Re: WA/68/26/PL — Land North of The Greenway, West Walberton Lane, Walberton, BN18 0QS

Further comments on WA/68/26/PL — boundary accuracy

Accuracy of the applicant's boundary as shown on submitted plans

Location Plan

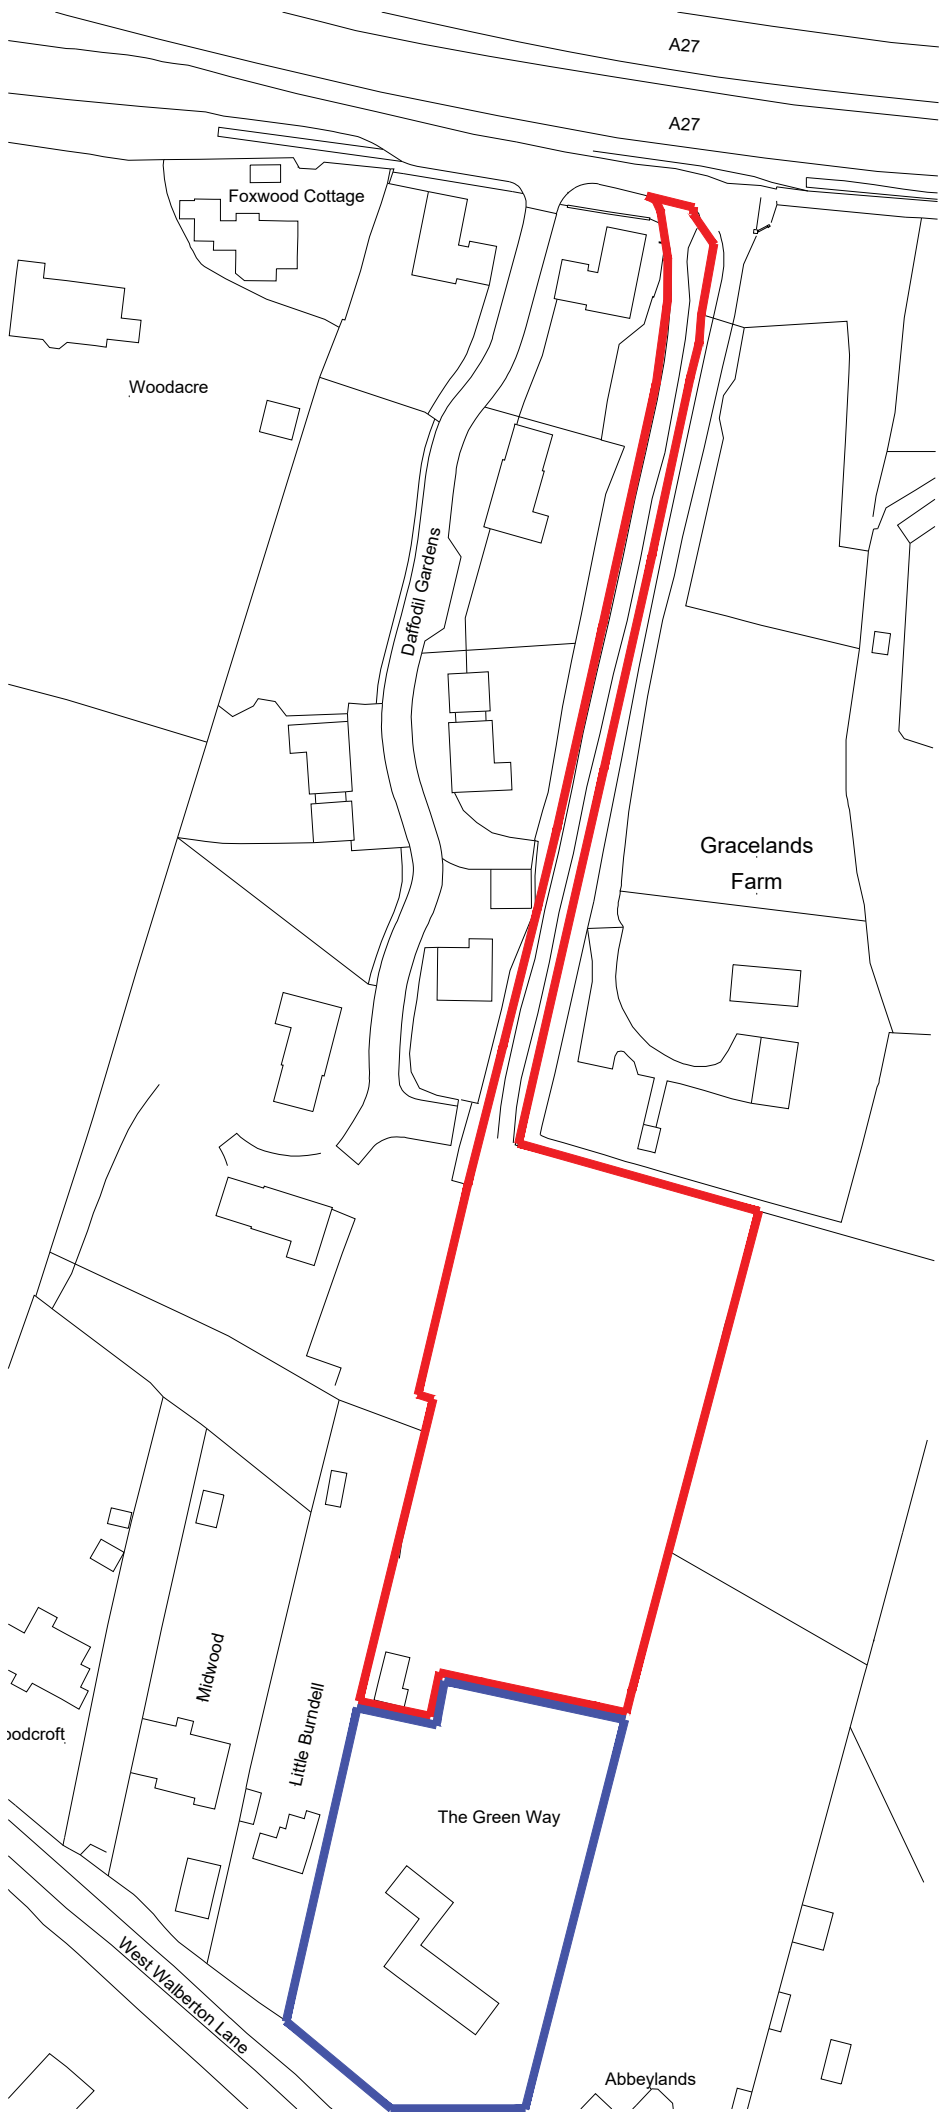
The application's drawings (Location Plan 1804/DP01, Proposed Block Plan 1804/DP02, and Proposed Site Plan 1804/DP03, all by Smith Simmons & Partners) identify the means of access as an existing track running from Arundel Road south past Gracelands Farm, alongside the eastern boundary of Plots 2, 4 & 6, Daffodil Gardens.

I have compared these drawings against Elivia Homes Southern's own Site Title Plan for the Daffodil Gardens estate (Drawing No. 54_17_150_B, "Plan 2", dated March 2022, revised 3 May 2024 — **copy attached**, as I understand this may not otherwise be readily available to you). On that plan, the same corridor is shown as two distinct strips — an area marked "Estate landscaped areas subject to right of way," and, immediately alongside it, a separate "300mm Wide Ransom Strip" — both narrowing noticeably as they approach the Arundel Road frontage. The application's own drawings, by contrast, show this corridor at a materially wider, constant width throughout, including at the road junction.

- What is the documented legal basis and width of the vehicular right of way the applicant is relying on for access?
- Does that right extend to the fuller width shown in the application drawings, or is it limited to the narrower corridor shown on the estate's own title plan?
- Has the applicant provided evidence of legal entitlement to use the access at the width shown — including in respect of the separate 300mm ransom strip, which by its nature is designed to require the owner's consent?
